WELWYN HATFIELD COUNCIL – DEVELOPMENT CONTROL
DELEGATED REPORT

APPLICATION No:	S6/2012/0096/FP
APPLICATION Site:	9 Wilkins Green Lane, Hatfield

The proposed development would involve the erection of a large two-storey extension which would have accommodation within the roofspace. To the rear of the existing property a section of the property would be demolished. To the front of the property two dormer windows would be positioned within the front plane of the roof. A detached garage would be sited to the western flank of the dwelling.

TITLE
 PROPOSED
 ELEVATIONS
 ADDRESS
 9 WILKINS GREEN LANE
 HATFIELD, AL10 9RT
 CLIENT
 Mr. & Mrs TITMUSS
 SCALE
 1:100 @A3
 DRAWING No.
 WGL 102-5
 DATE
 JAN 2012
 REV.
 -

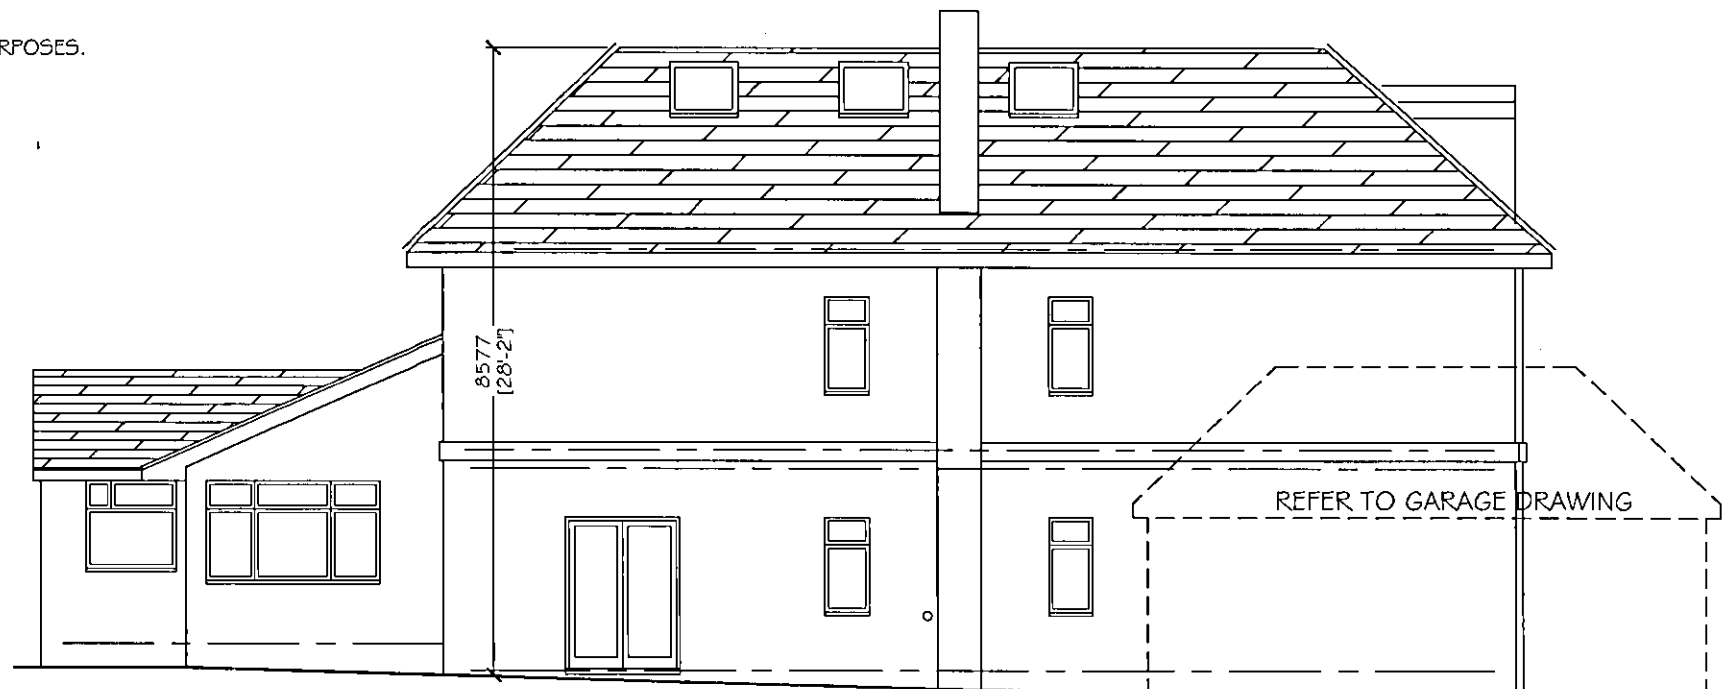
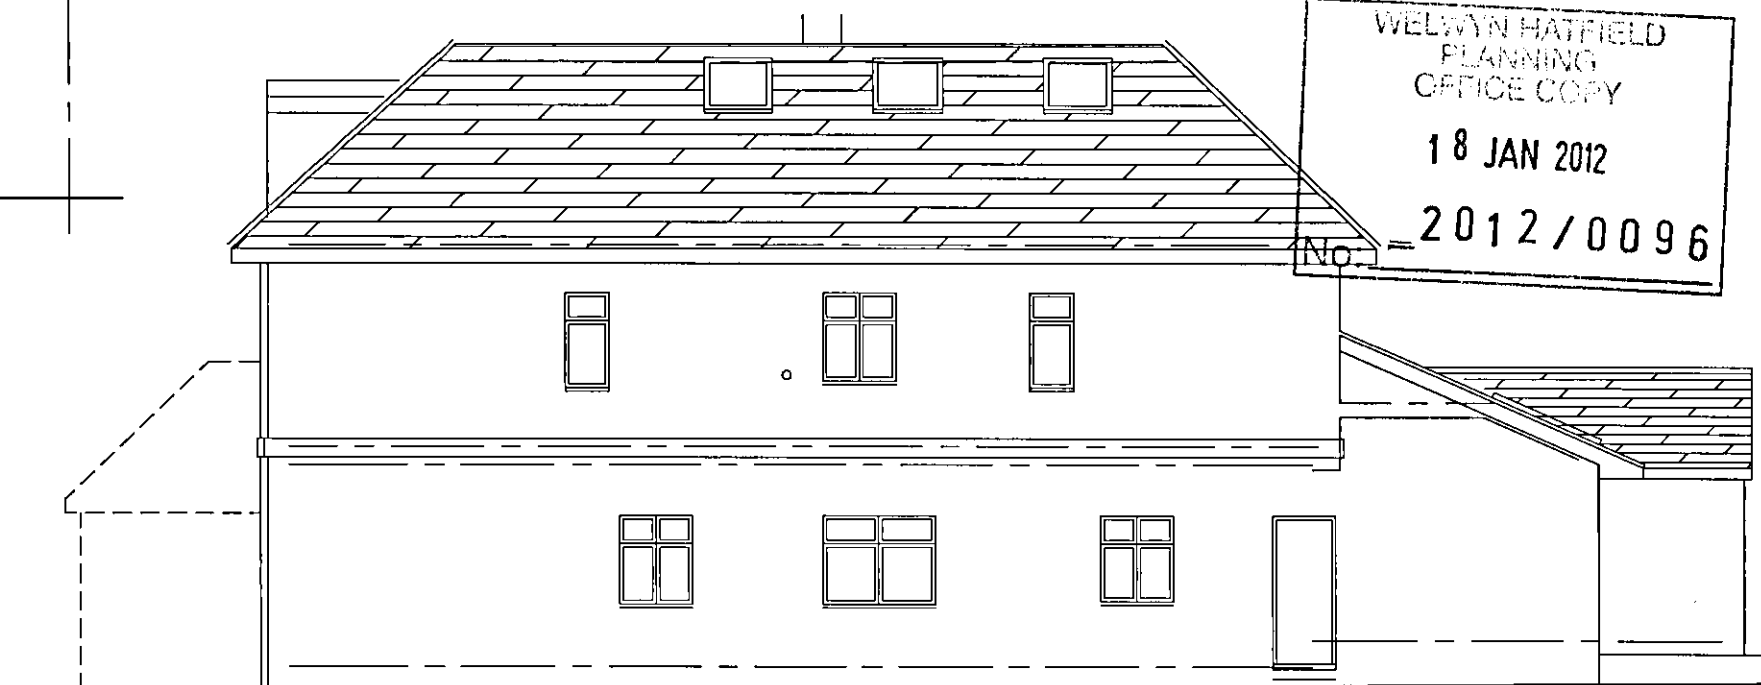
The proposed development would add to the existing dwelling significantly and would not be subordinate in scale. To the front of the property the proposed extensions would be 2 ½ storey in appearance and the resultant height, width and depth of the dwelling would give it a large and dominant appearance. When travelling along Wilkins Green Lane the properties are generally two-storey in appearance as a maximum. The properties to the east have hipped roofs and appear in proportion with the plots and surrounding features.

The proposal's depth would be significant and although it is accepted that the existing property has a relatively large footprint and depth, this is often the case with bungalows, and two-storey properties usually have very different proportions. Due to the depth of the proposal at first floor level a large flat roof is required to prevent it from being excessively tall. As a result the proposal would appear bulky, boxy and dominant which is not a feature of the surrounding dwellings and this would not achieve an acceptable standard of design.

The existing dwelling is set forward of the adjacent dwelling to the west (no 10) and the proposed development would all be to the front of this adjacent property. The western flank wall of the proposal would have a depth of approximately 14m at first floor level and the large flat topped roof would give the property a bulky overly dominant appearance. When accessing number 10 the resultant dwelling would appear overly prominent and out of proportion with the scale of dwelling within this area. Glimpses of the additional depth at ground floor level would worsen the appearance of the dwelling and its excessive depth. The resultant dwelling's prominence and odd appearance due to the excessive depth and large flat roof would not respect the character and appearance of the locality.

The proposal would be set back beyond the rear of number 8. The proposed development would have a two-storey depth of approximately 8.5m beyond the original rear elevation of the number 8. This depth would extend to be over 12m when the single storey element of the application dwelling is taken into account.

It is acknowledged that number 8 has an existing single storey rear extension which would be approximately 4m forward of the proposed two-storey extension. Although the ground floor area of number 8 would not suffer an adverse impact due to the depth of the proposal, the outlook from the first floor windows which are within the original dwelling would suffer an adverse impact. As existing the depth of the dwelling is very deep when considering the position of number 8. However, the proposed extensions to this side of the property would be tall, bulky and have an unacceptable cumulative impact.

TITLE
**PROPOSED
 FIRST FLOOR PLAN**
 ADDRESS
**9 WILKINS GREEN LANE
 HATFIELD, AL10 9RT**
 CLIENT
Mr. & Mrs TITMUSS
 SCALE
1:100 @A3
 DRAWING No.
WGL 102-2
 DATE
JAN 2012
 REV.
 -

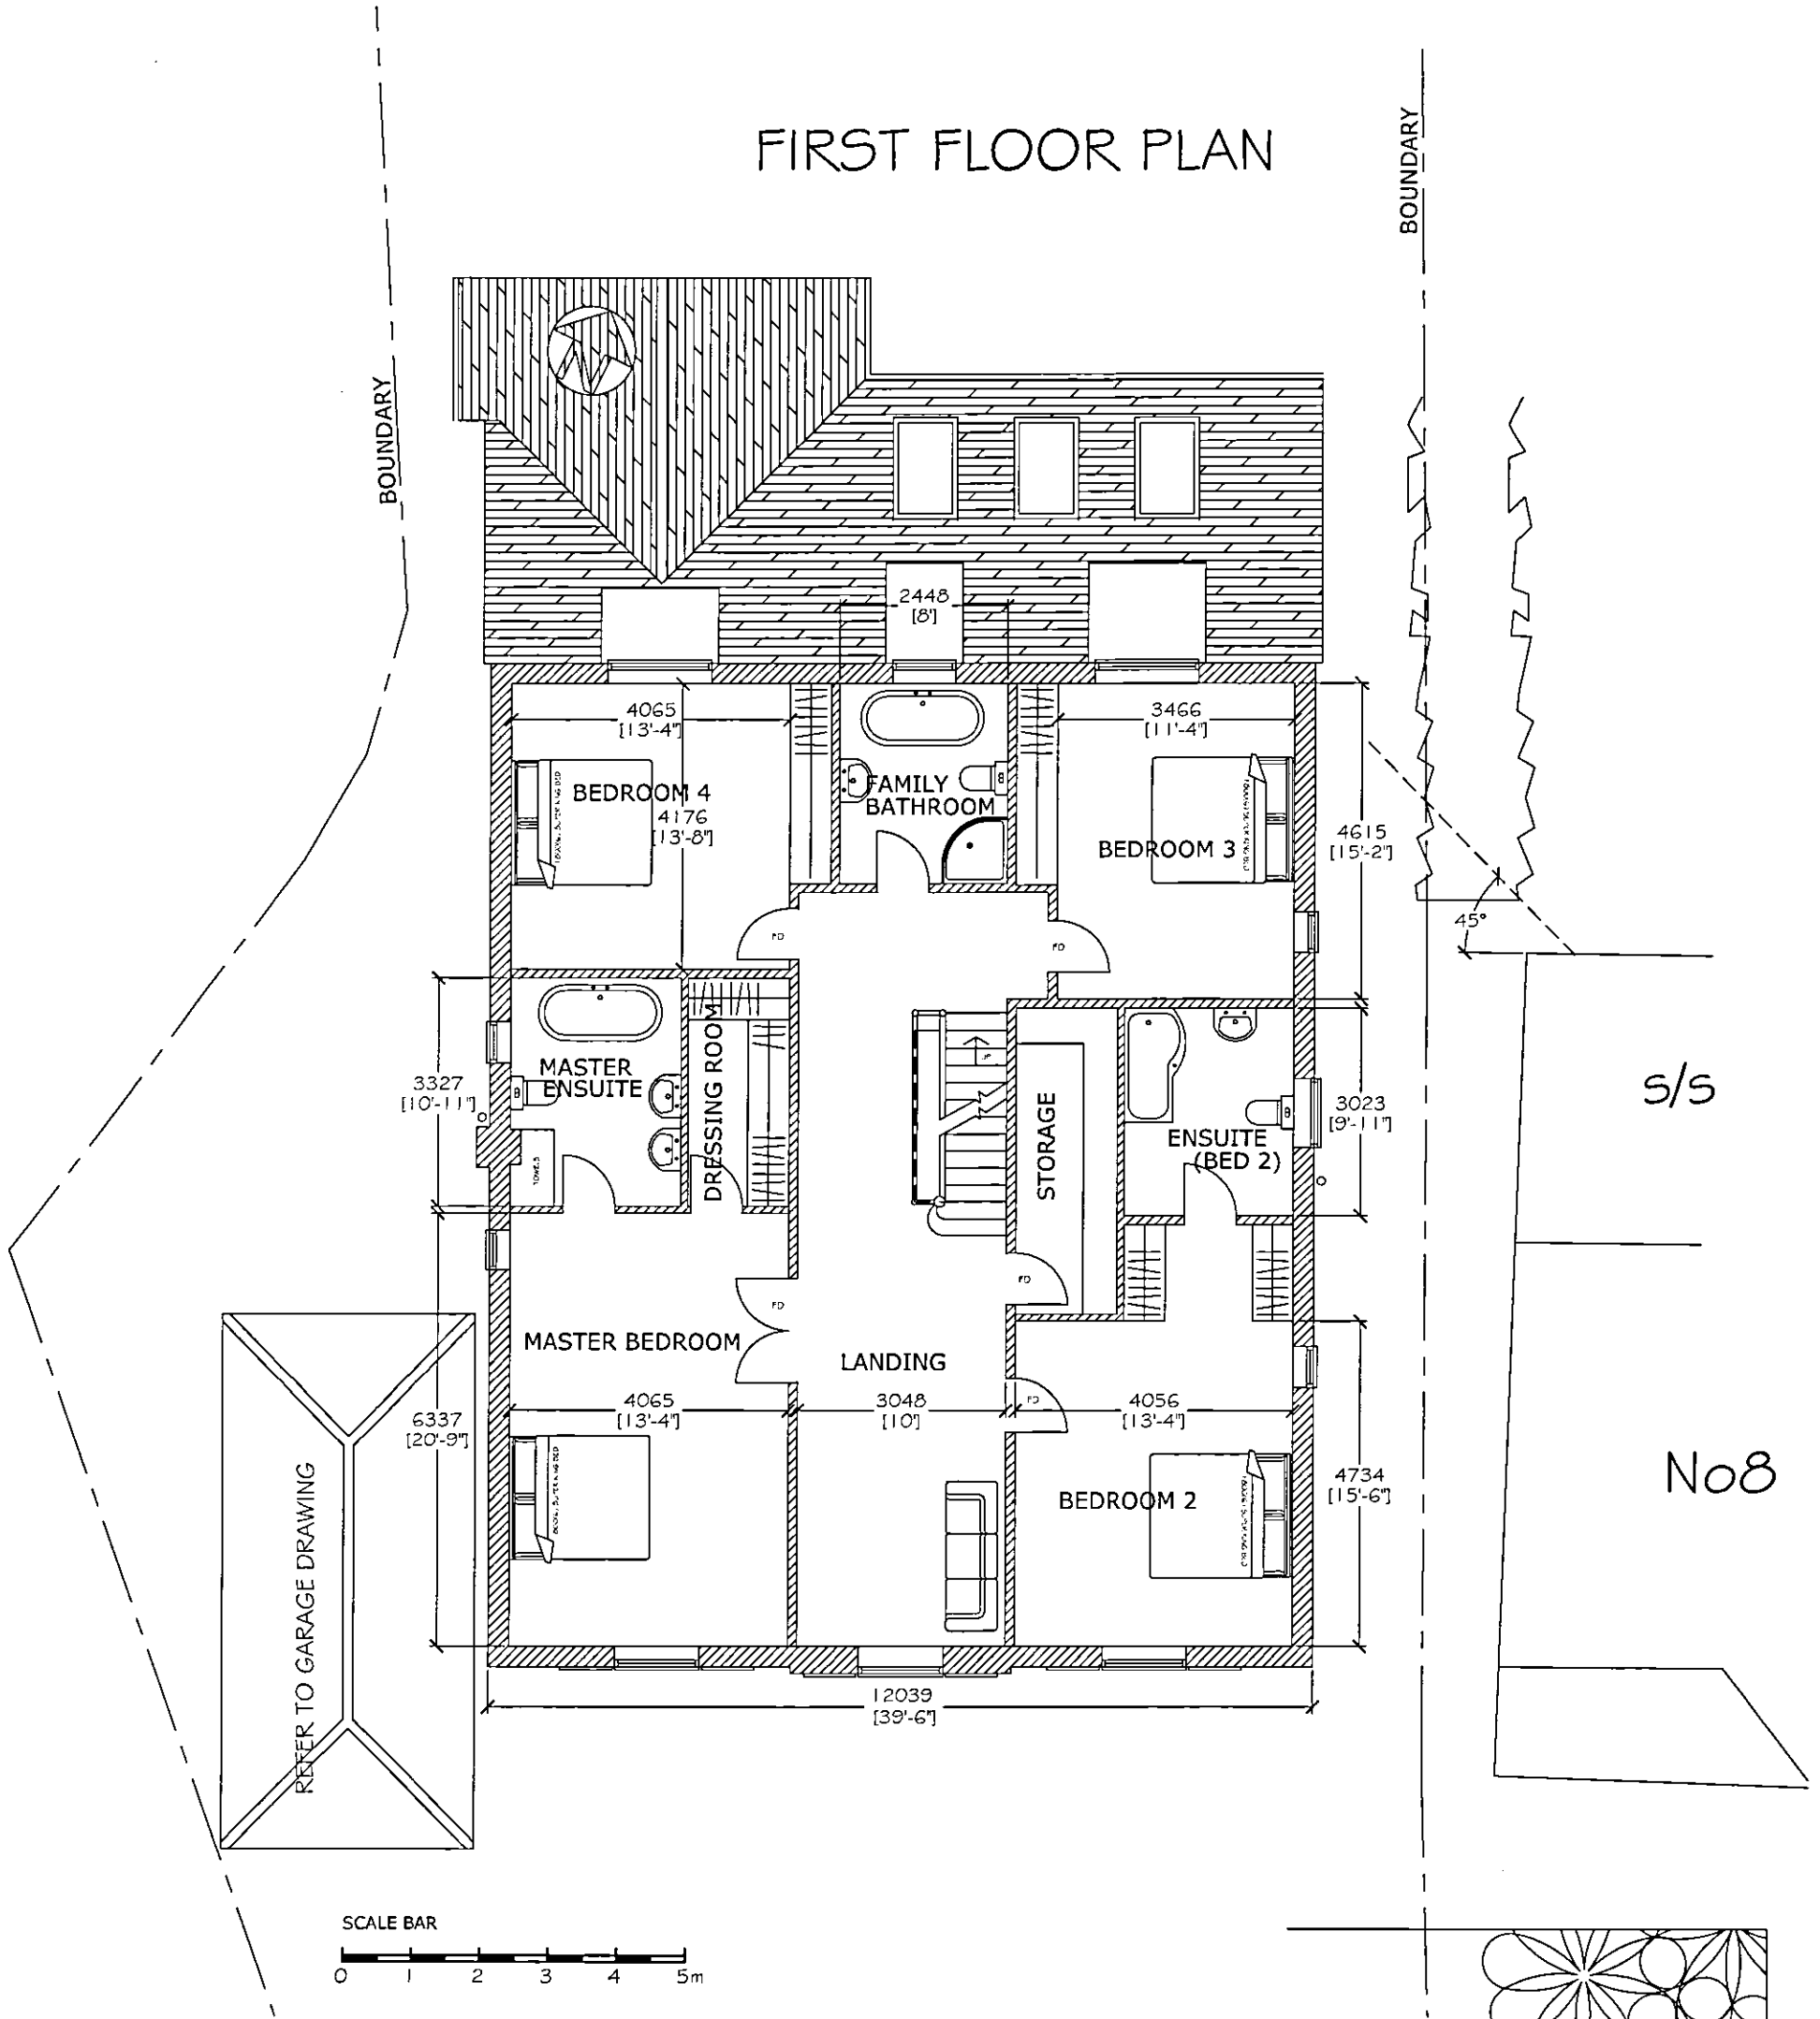
The proposal would involve construction of a bedroom at first floor level to the western side of the rear elevation. Although the window to this room would not have a direct back-to-back relationship, it would be too close to the bedroom window within the front elevation of number 10. As a result this window would result in direct and perceived overlooking of number 10. Due to the proposed height this would be far worse than the existing ground floor windows that have a view towards number 10.

3. The proposed development by reason of its layout design and positioning of windows within the rear elevation would result in overlooking of the adjacent dwelling to the west (no 10). This overlooking and perceived overlooking of windows within the front elevation of number 10 would result in a direct loss of privacy and residential amenity. The proposal is therefore contrary to the National Planning Policy Framework and Policy D1 of the Welwyn Hatfield District Plan 2005.

DRAWING No.
WGL 102-20

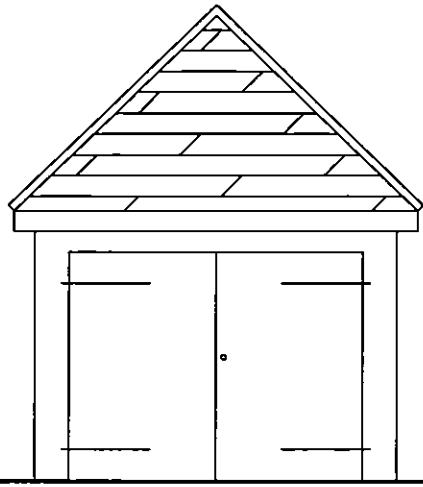
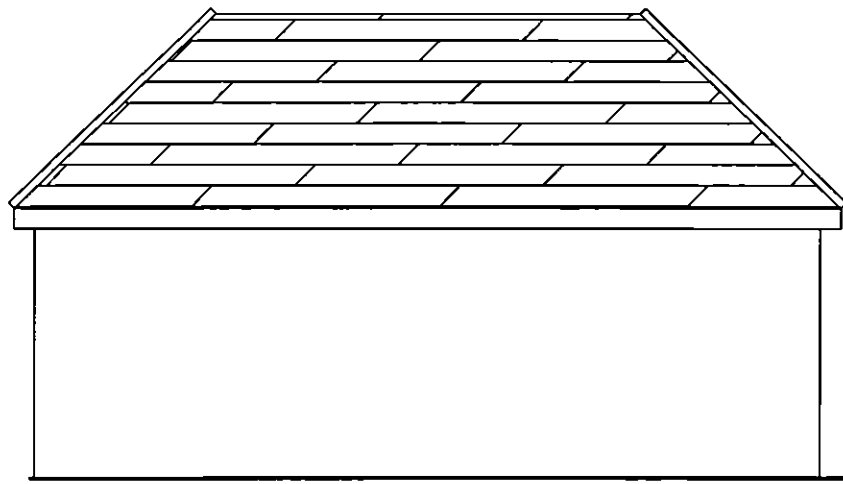
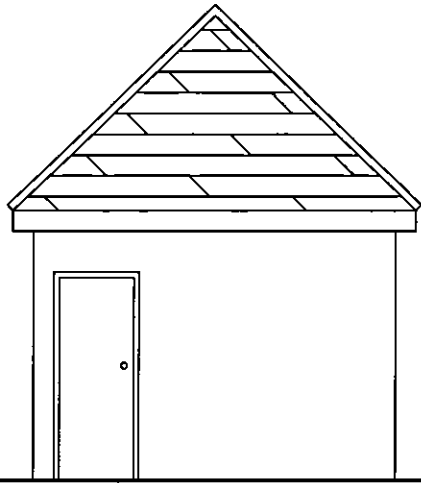
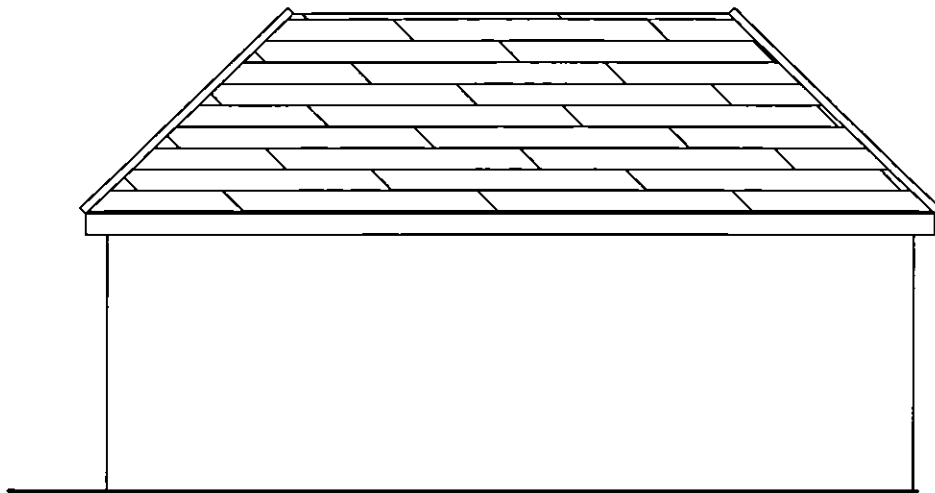
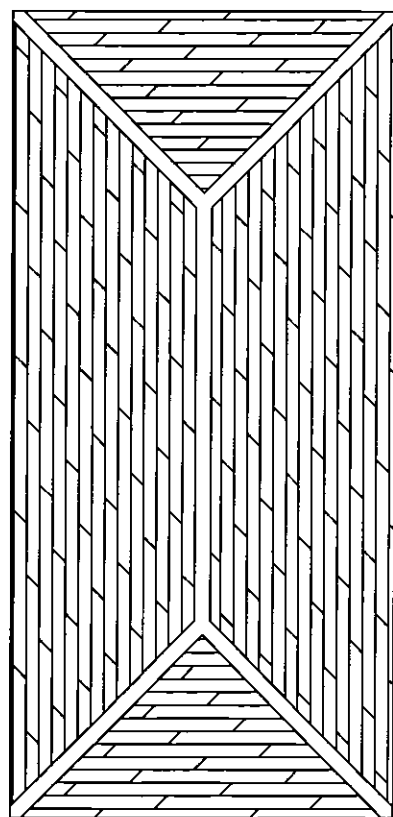
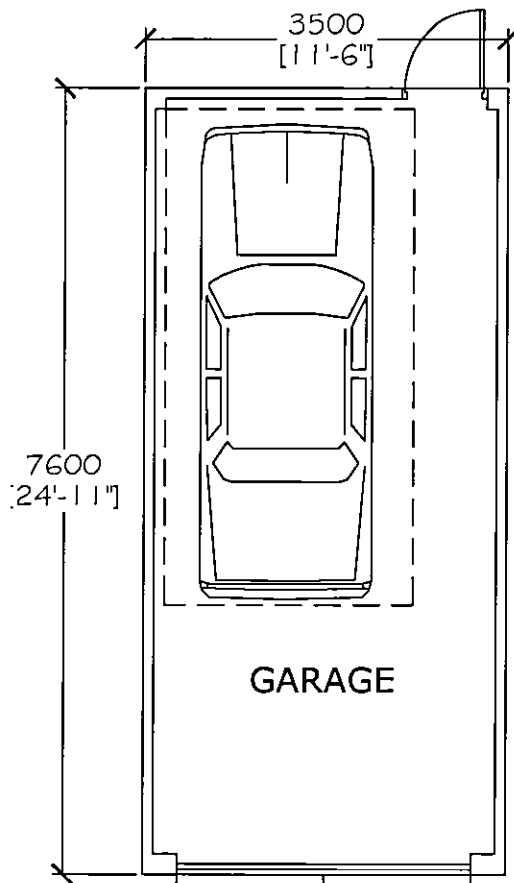
The proposed garage would not be sited in an ideal location as due to the boundary position and proximity of the dwelling it would appear cramped and contrived. Although there is not space to comfortably accommodate the proposed garage, due to the relatively low height and its relatively small size, it would not appear overly prominent or have an adverse impact upon the character and appearance of the site.
